Application number: 2024/93068	
What is the application for?:	Erection of two storey side extension, single and two storey rear extension and f
Address of the site or building:	1, Chadwick Crescent, Dewsbury, WF13 2JF
Postcode:	WF13 2JF

Type of comment: An objection	
Do you wish your comments to be published on the website anonymously?	Yes
This site must be distinguished from others on the estate due to the unique relationship with 15 Infirmary Road. The primary concern remains that the proposed extension would be attaching onto the boundary of 15 Infirmary Road which sits at an elevated position. The combination of the site location, its setting, its unique relationship with 15 Infirmary Road as well as the sheer scale of the proposed extensions, all results in an application which is ill considered and would not form subservient additions to the host property. If the proposed plans were to be approved it would result in a building that would be at odds with its surroundings and thereby harm the visual amenity. It would alter the character of the property contrary to policy LP24 of the Kirklees Local Pla, KDP1 and KDP2 of the House Extensions and Alterations SPD and chapter 12 of

PROPOSED GROUND FLOOR PLAN
 SCALE 1:100 @ A1

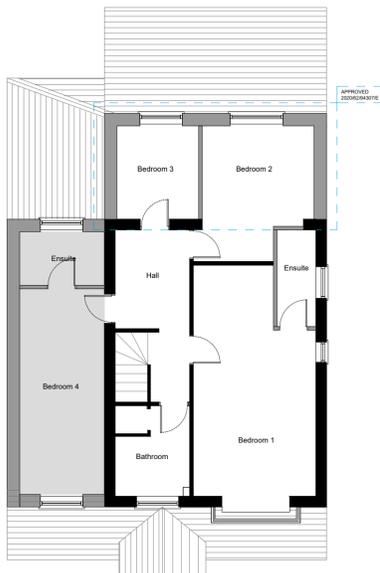
The proposed ground floor 14 meter side extension would connect with the existing detached garage. If approved the occupants of 15 Infirmary Road would look onto 20 meters of walling at ground level and 9 meters at first floor level thus decimating their amenity value. I therefore invite you to refuse this application.

PROPOSED SIDE ELEVATION
 SCALE 1:100 @ A1

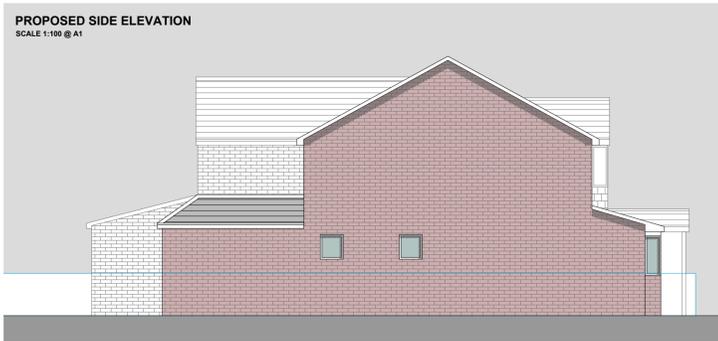
The plans show windows on the side extension, these look directly onto the garden and habitable rooms of number 15. Raised windows have been proposed but this doesn’t alleviate concerns given 15 Infirmary Road is on a higher ground. Once opened they would have unobstructed view across the rear amenity space. This would infringe on Article 8 of ECHR.

The height of the proposed development with particular regard to the side and rear elevations would create extreme overbearing, overshadowing and would result in a visually intrusive impact. The fact this latest plan is slightly reduced in size from the previous application makes minimal difference as all previous concerns remain.
